Our ref: DOC25/337782
Your ref: SSD-10269-Mod-1

Narrabri Underground Mine Stage 3 – Modification 1

Narrabri Underground Mine Stage 3 – Modification 1

Figure 2: : Indicative Development Footprint Disturbance Area

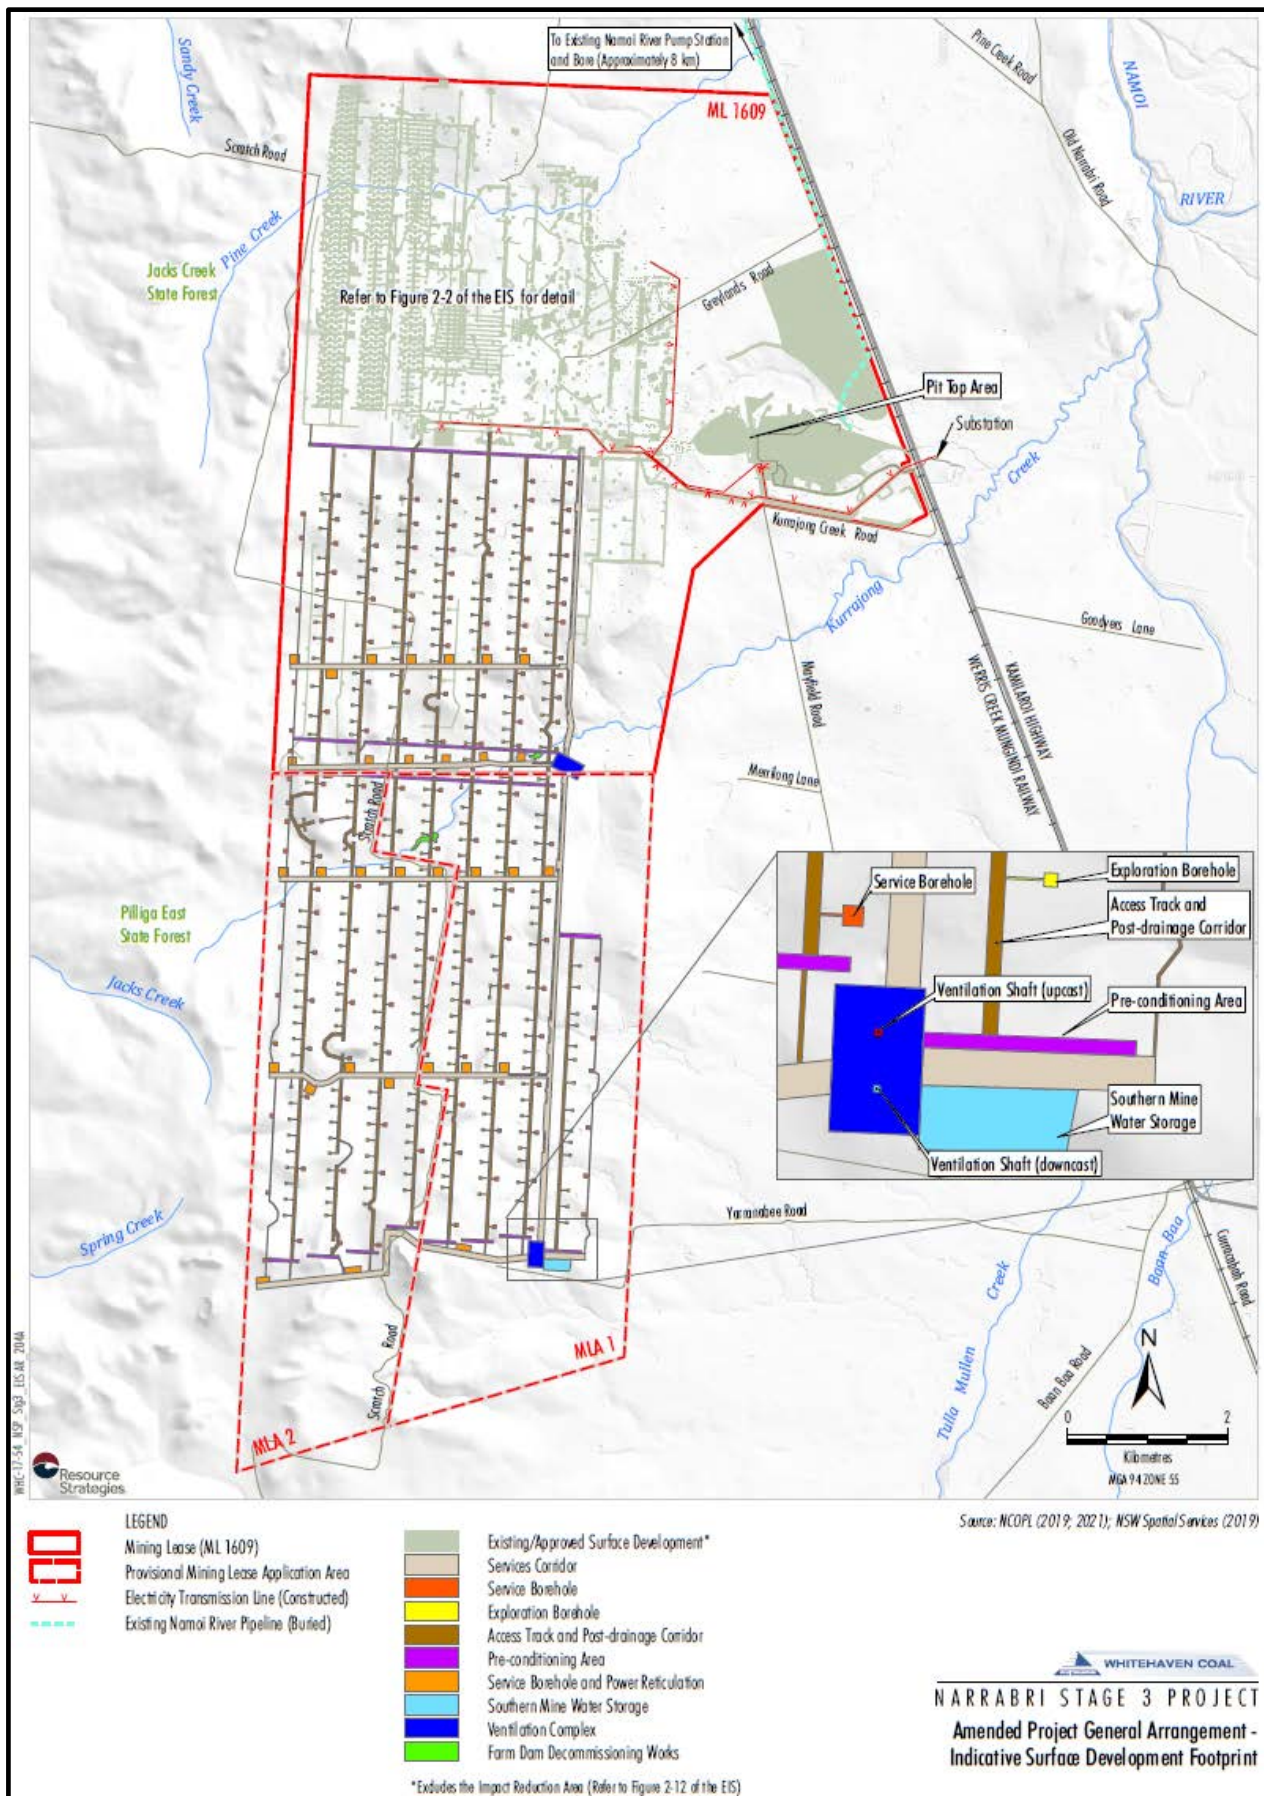
The modification document references an approval provided by DPHI in March 2025 to reduce the project's impacts by removing several development components e.g. access tracks, boreholes, etc. However, the figures in the submitted modification report still include these as approved project components (See Figure 2).

It is important that the modification report and Appendix 2 of the Stage 3 consent accurately reflects the modified project design, so that impacts and the associated credit obligation can be tracked through time.

- 1.1 Revise Figure 2 of the modification report to accurately reflect the approved reduced project design. This revision should also be updated in Appendix 2 of the Stage 3 consent, if MOD 1 is approved.

Figure 3: Project Phasing for Offsets

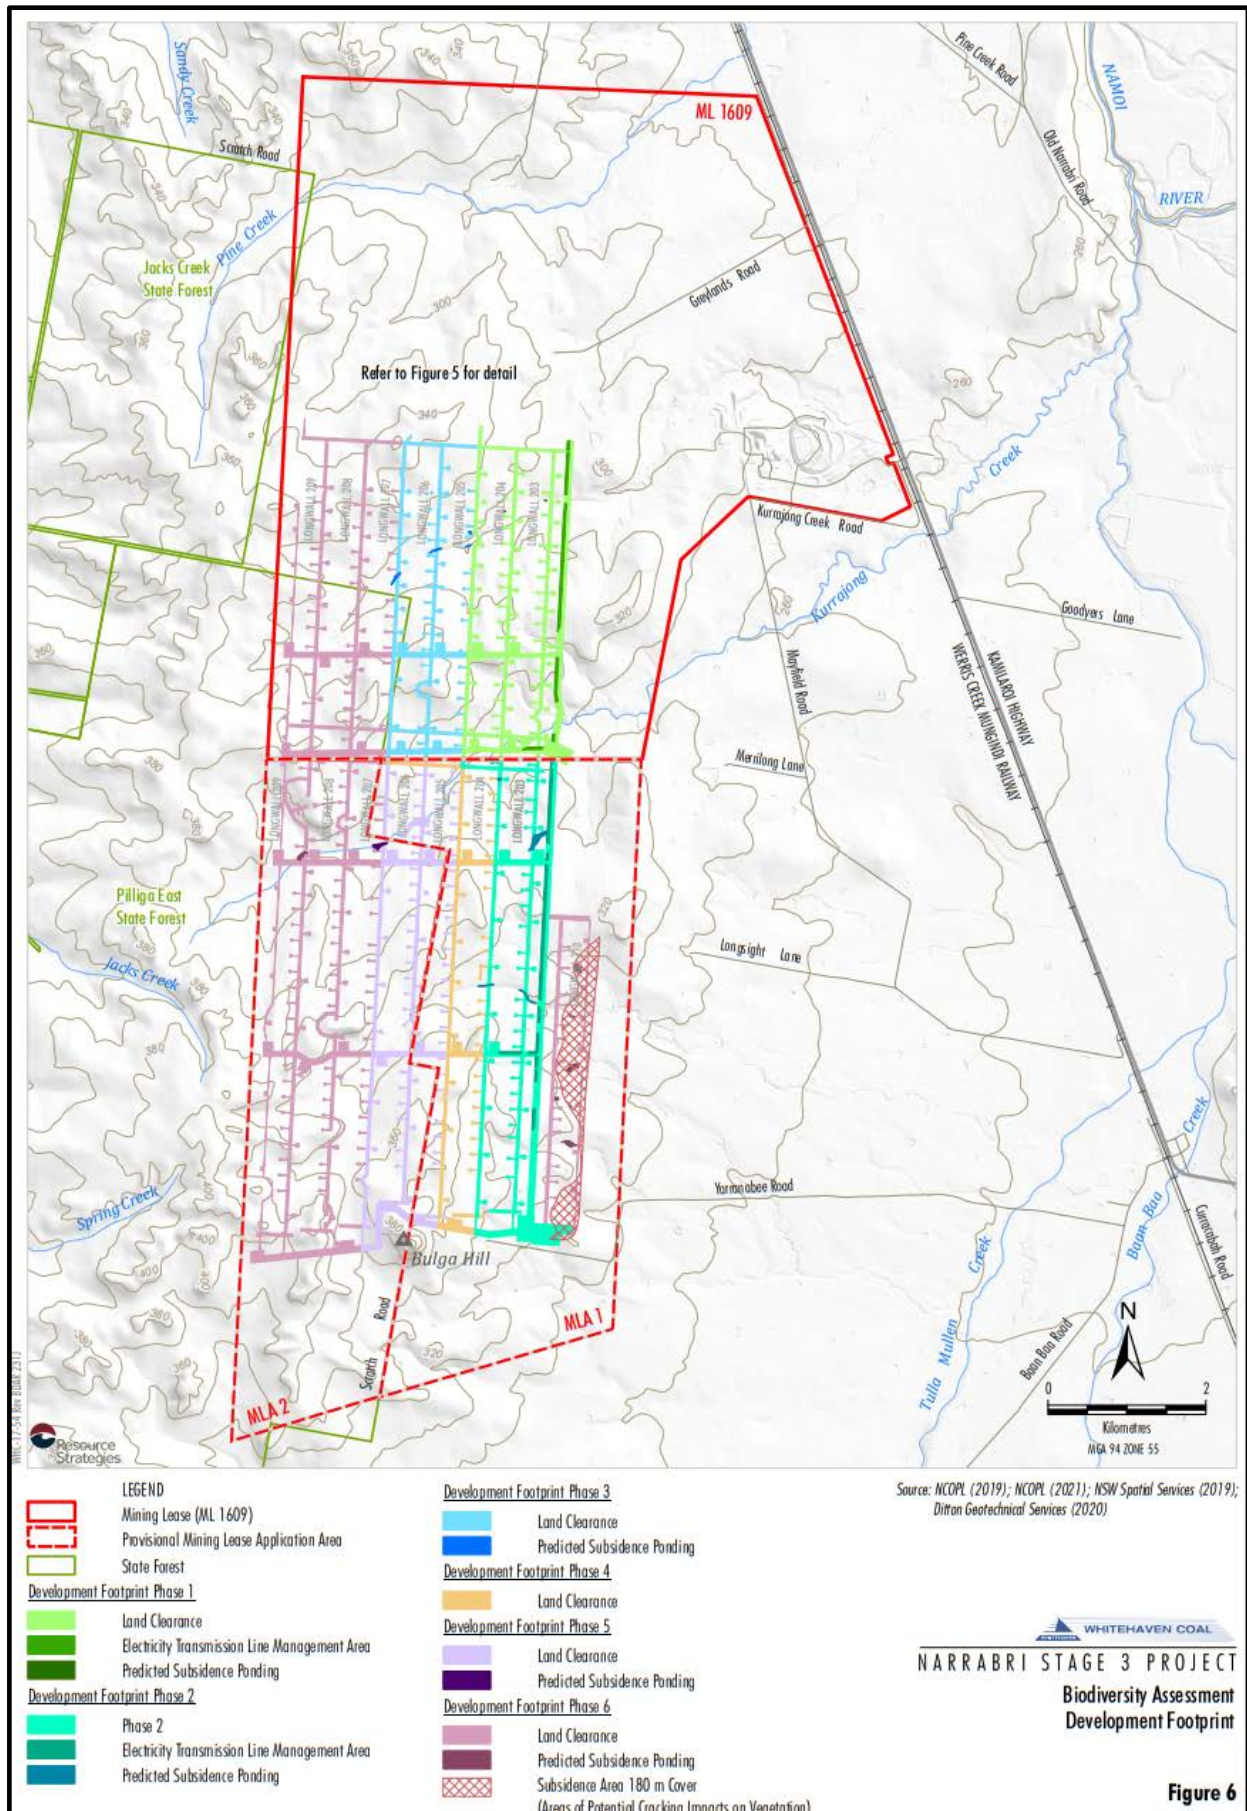
The proponent has proposed to modify the staged credit retirement for the project, separating areas of predicted subsidence ponding from the overall impacts of the project. This has the potential to result in impacts from subsidence ponding occurring prior to these impacts being offset.

Table 7 of the conditions of consent requires the retirement of biodiversity credits prior to the commencement of any impacts, including land clearance and longwall mining (defined by each stage of the development). This accords with the requirements detailed in section 7.14(4) of the BC Act. The impacts of predicted subsidence ponding have been included within each stage, as these impacts will occur indirectly from longwall mining activities.

The timing of ponding impacts occurring will be dependent on several factors that cannot be accurately predicted, such as rates of subsidence activity post-underground mining and rainfall patterns. This presents a risk that the impacts of ponding may occur before the offsetting of these impacts has been undertaken. As such, creating separate offsetting stages specifically for indirect subsidence ponding would not be appropriate.

4.1 Staging of the project is not revised to separate the indirect impacts of subsidence ponding from the direct impacts of vegetation clearance.
